# **A12 Chelmsford to A120 widening scheme**

**TR010060**

## **9.33 Applicant's Comments on Chelmsford City Council's Local Impact Report**

**Applicant's Comments on Chelmsford City Council's Local Impact  
Report**

FIGURE 6.10

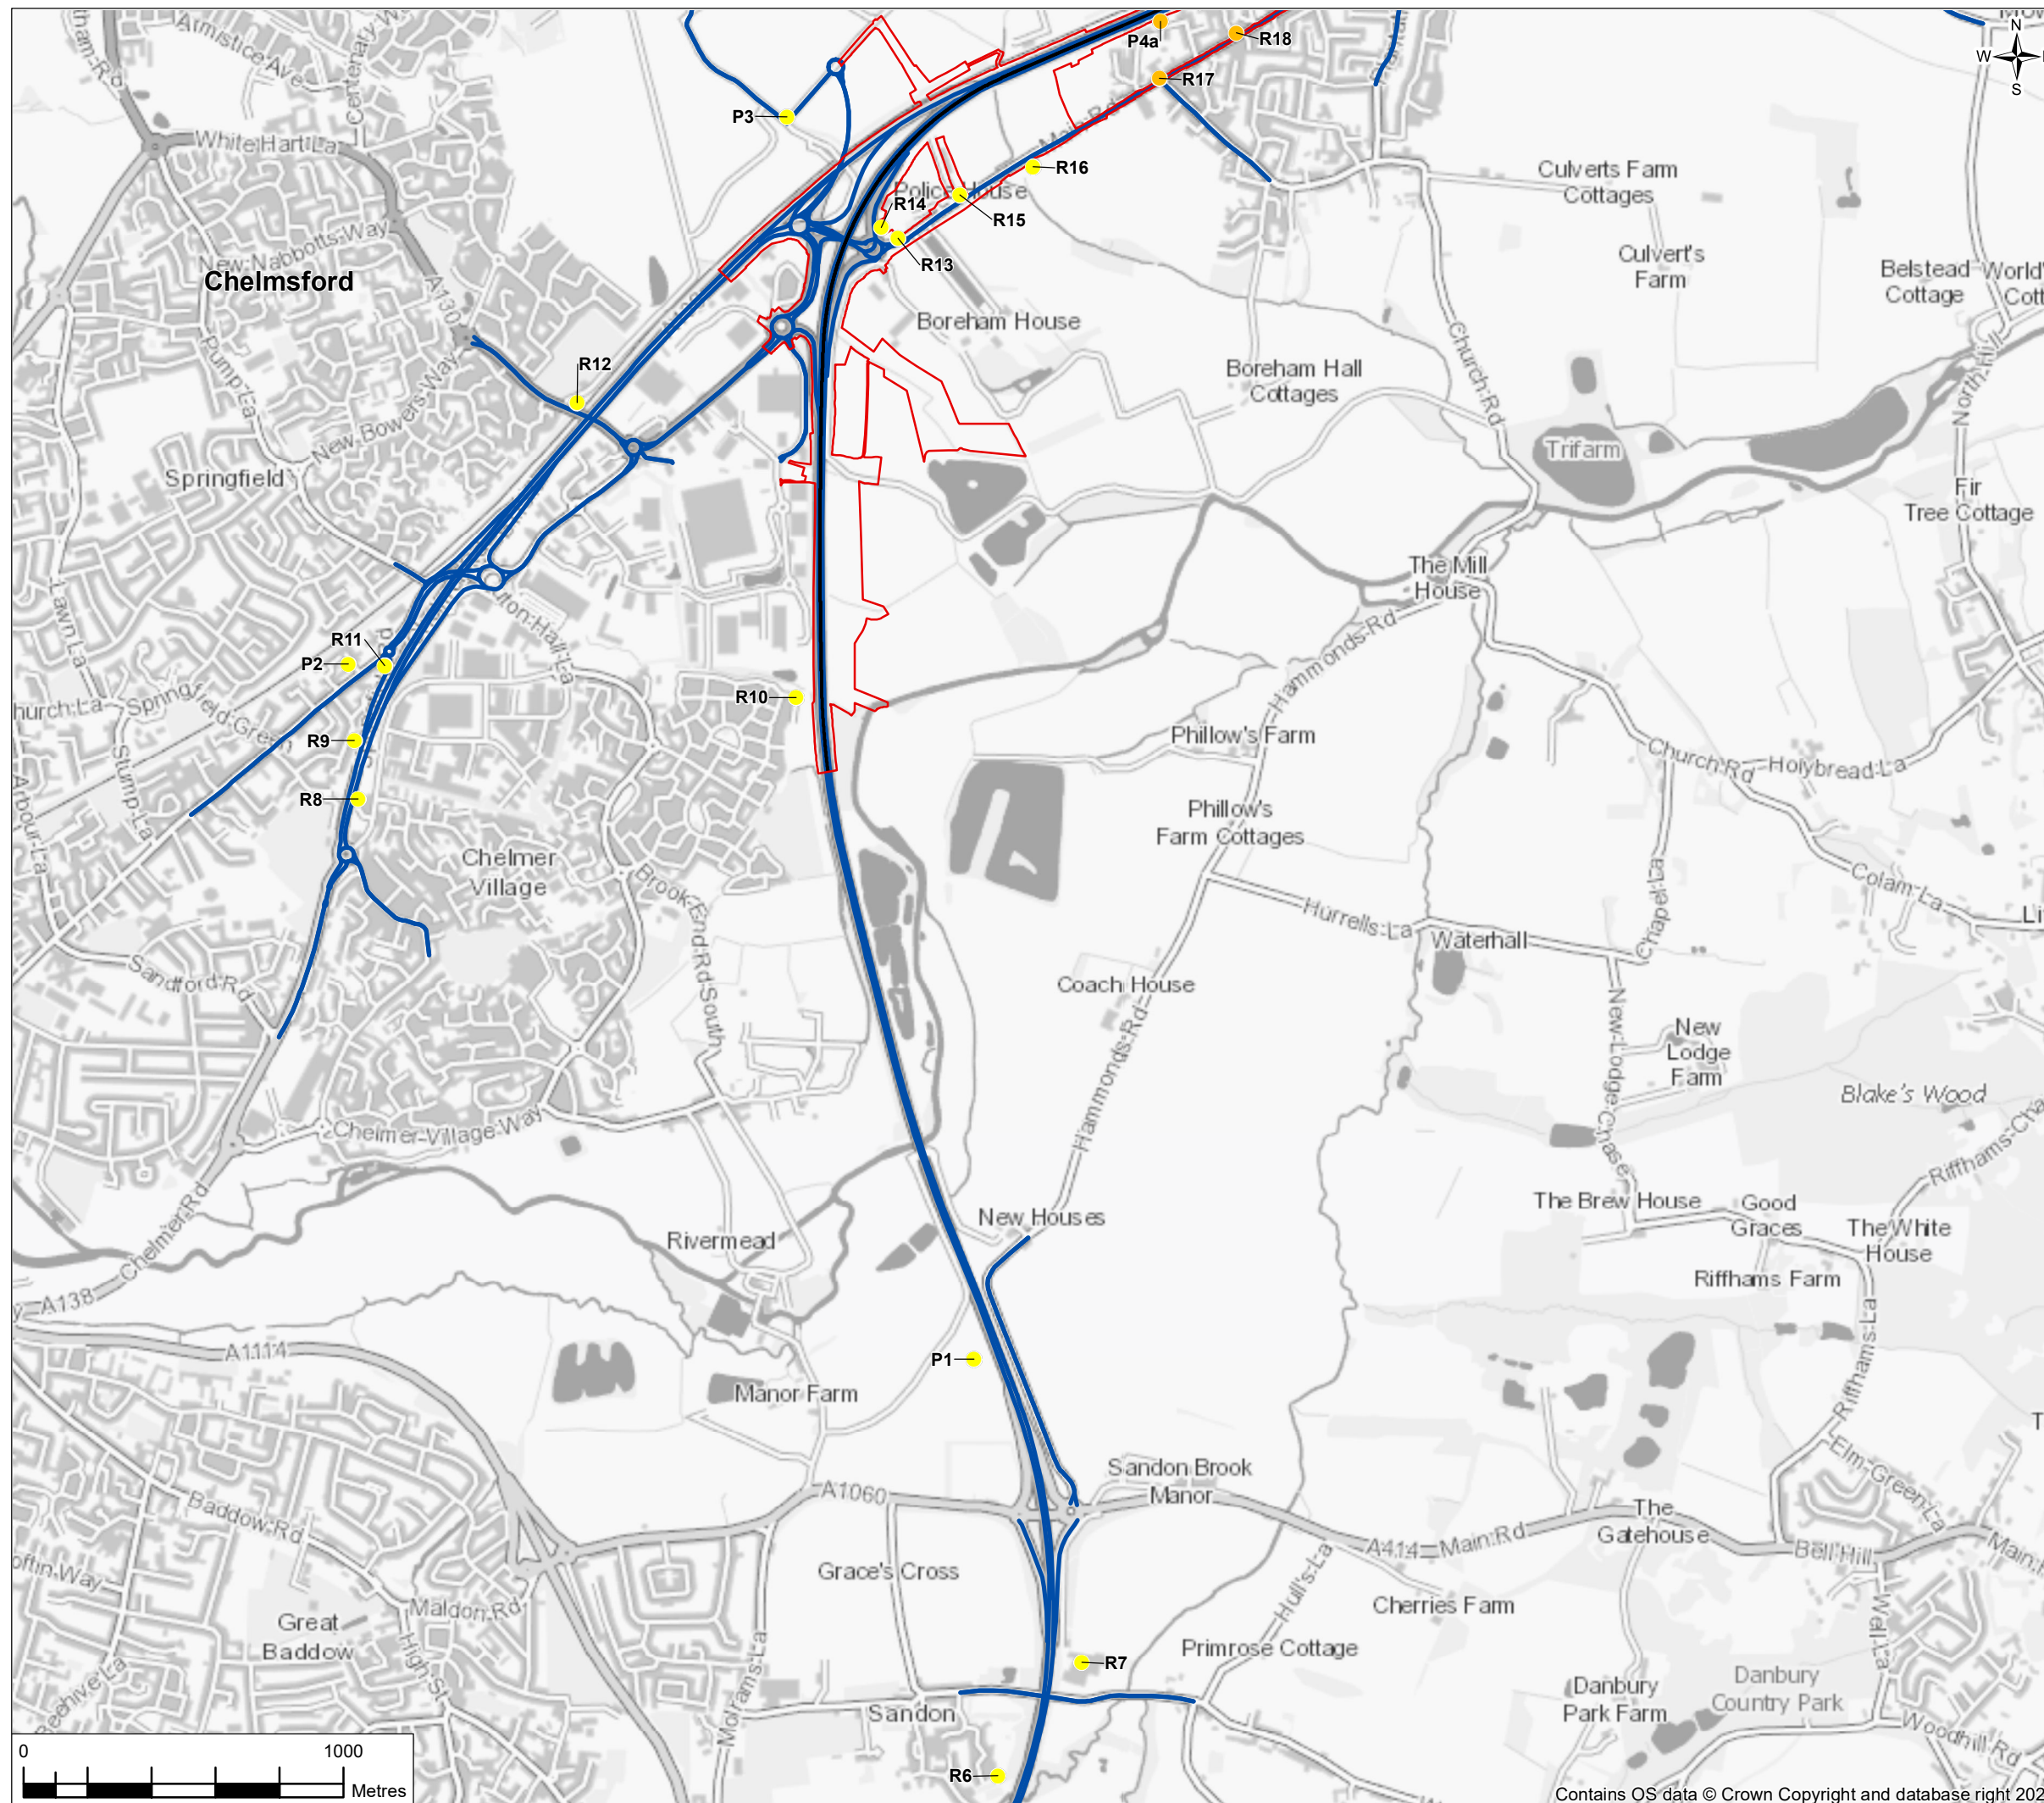
The Applicant acknowledges the position of the Chelmsford City Council with regards to the impact of the proposed scheme on air quality in Boreham. The UK Air Quality Standards are a range of pollutant concentrations recorded over a given time period, which are considered to be acceptable in terms of what is scientifically known about the effects of each pollutant on health and on the environment. Predicted pollutant concentrations are compared against the Standards.

Of the sensitive receptors considered along Main Road Boreham and Plantation Road, only one receptor (R225) located approximately 10m from the A12 was predicted to exceed the UK Air Quality Standards (UK Air Quality Standards Regulations, 2010) for annual mean NO<sub>2</sub> as a result of increased traffic flows and changes in speed characteristics on the A12 and Main Road.

The predicted total was 40.3µg/m<sup>3</sup> with an increase of 4.0µg/m<sup>3</sup>. Nearby properties (Receptors R30 and R224) did not experience the same magnitudes of increase, nor exceed the UK Standard of 40µg/m<sup>3</sup>. Predicted concentrations of particulates were within the UK Air Quality Standards at all locations here. Please refer to the results presented in Appendix 6.5 [APP-104] and Figures 6.9 and 6.10 of Appendix 6.2 [APP-213 and APP-214 respectively].
